An
Bord
Pleanála

Inspector's Report ABP-310078-21

Strategic Housing Development

165 no. residential units (105 no. houses, 60 no. apartments), creche and associated site works.

LAYOUT OF PROPOSED FOOTPATH TO POWERSCOURT NATIONAL SCHOOL CROSSING

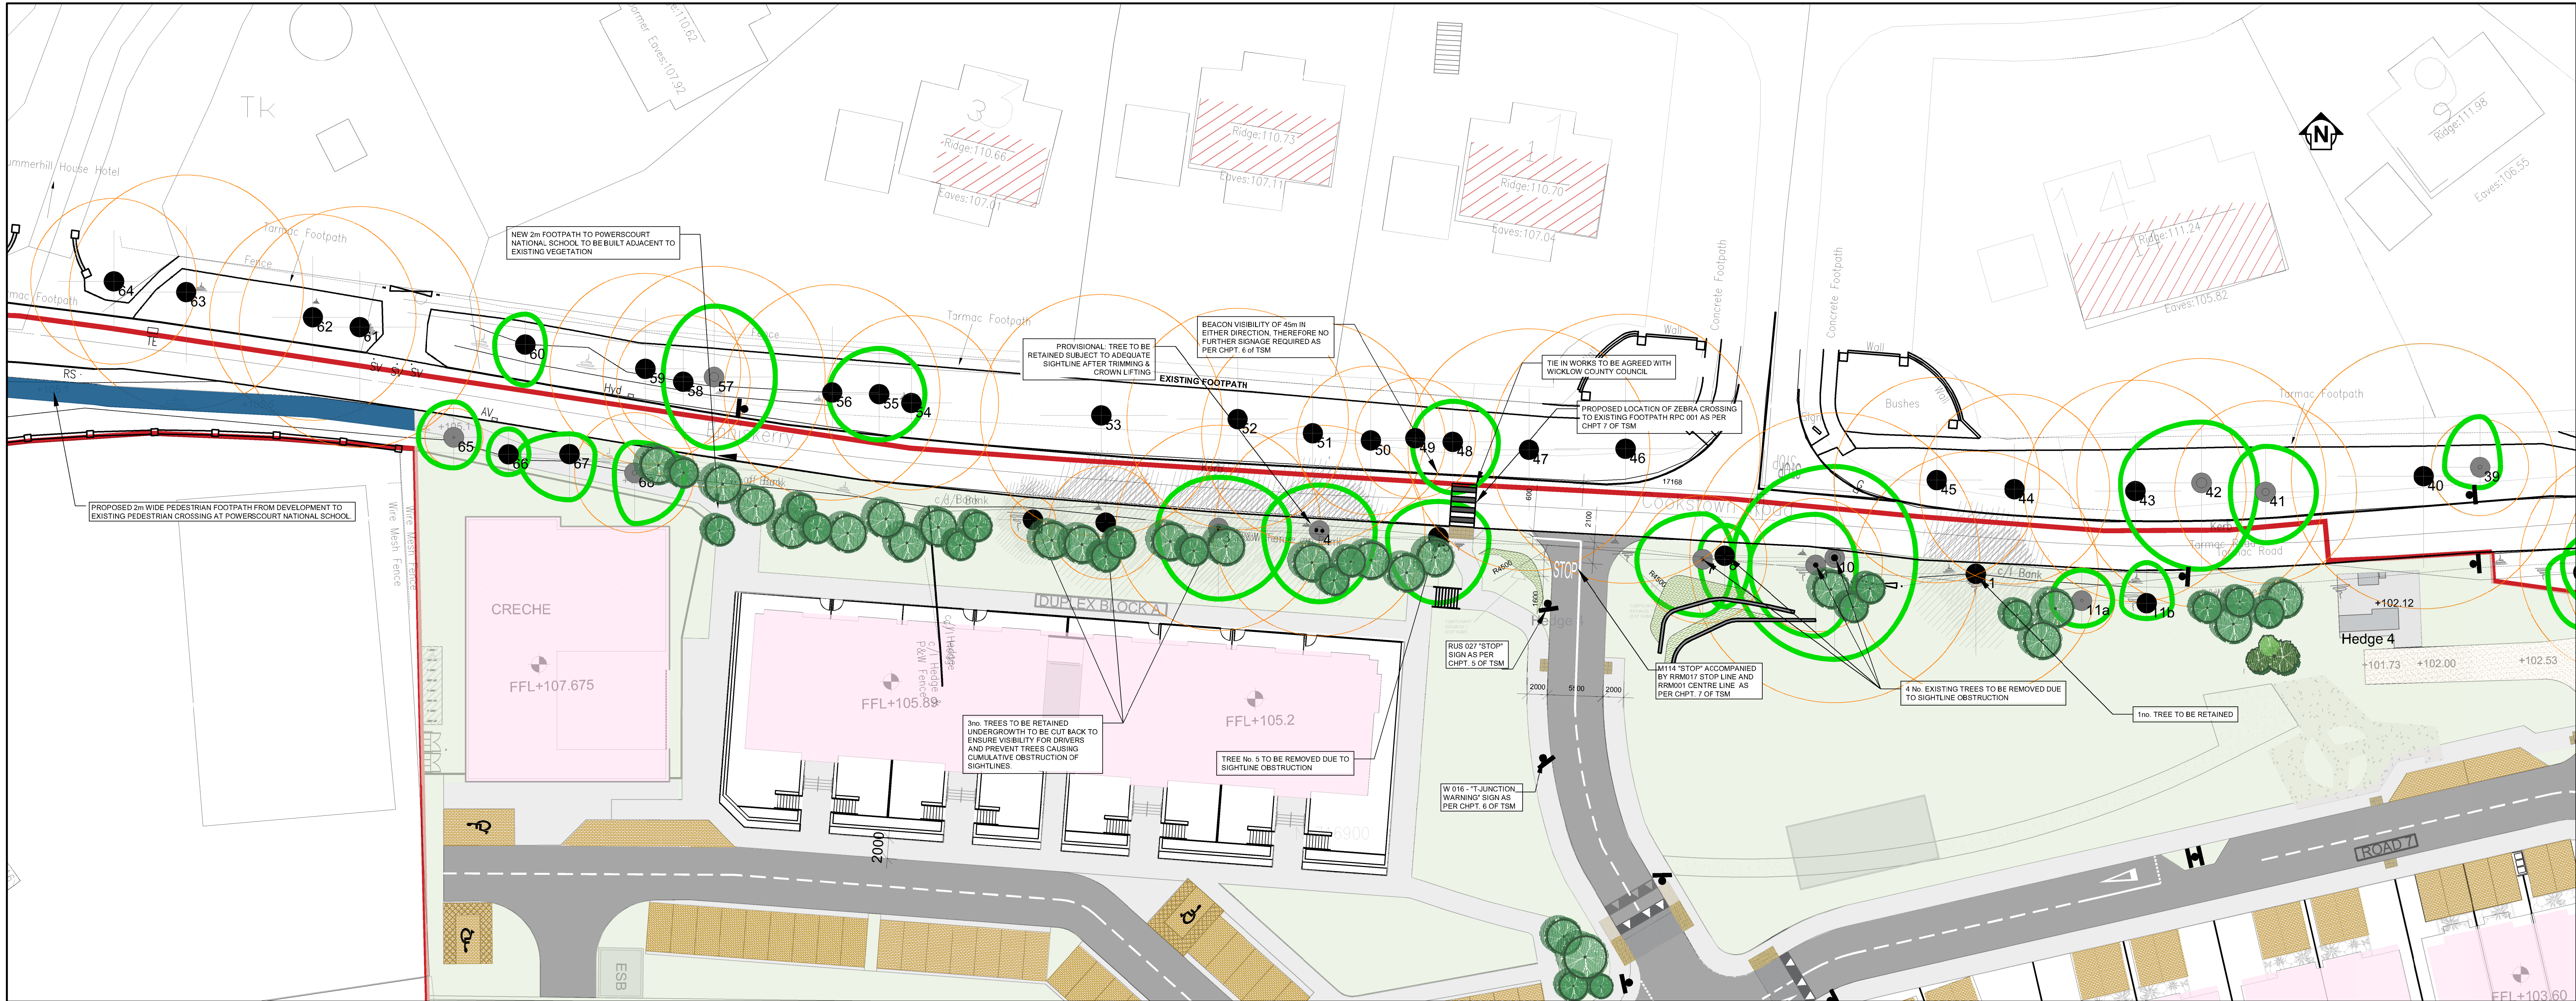
- The Traffic Impact Assessment (TIA) is not sufficient.
- The site is served by the L1020 which is a poorly aligned rural road and is inadequate in terms of drainage, public lighting, and public footpaths.
- The applicant has not demonstrated that the existing road network can be upgraded to cater for the volume of traffic likely to be generated by the proposal.
- The proposal for the new footpath along the southern side of the Cookstown Road fails to adequately consider the ground levels to the front of the school.

- Pedestrian Facilities: Details of the ground level difference in the footpath outside the national school, removal of steps and further details of crossings and footpaths in the proposal.
- Roads: It was requested the road was widened to 5.5m, the road is only 5m, design of internal road layout and materials for home zones.
- Road Safety Audit (RSA): RSA stage 2 for the construction drawings and RSA stage 3 for the improvements at Cookstown Road and within the proposed development.
- Traffic Assessment/ Traffic Impact Assessment: No assessment of some of the junctions on the approach to and within the heart of the village of Enniskerry are included and query the distribution of traffic from the proposed development.
- Public lighting: Additional drawings requested in relation to the design.

4. Part V
5. Road Safety Audit: Stage 2 Road Safety Audit and Final Audit Report to be prepared in line with TII publications.
6. Roads/ Pedestrian Facilities: Final details of all internal roads, footpaths, home zones, upgrade works to Cookstown Road and footpath along the southern side of the Cookstown Road to the pedestrian crossing at the National School, to be agreed.
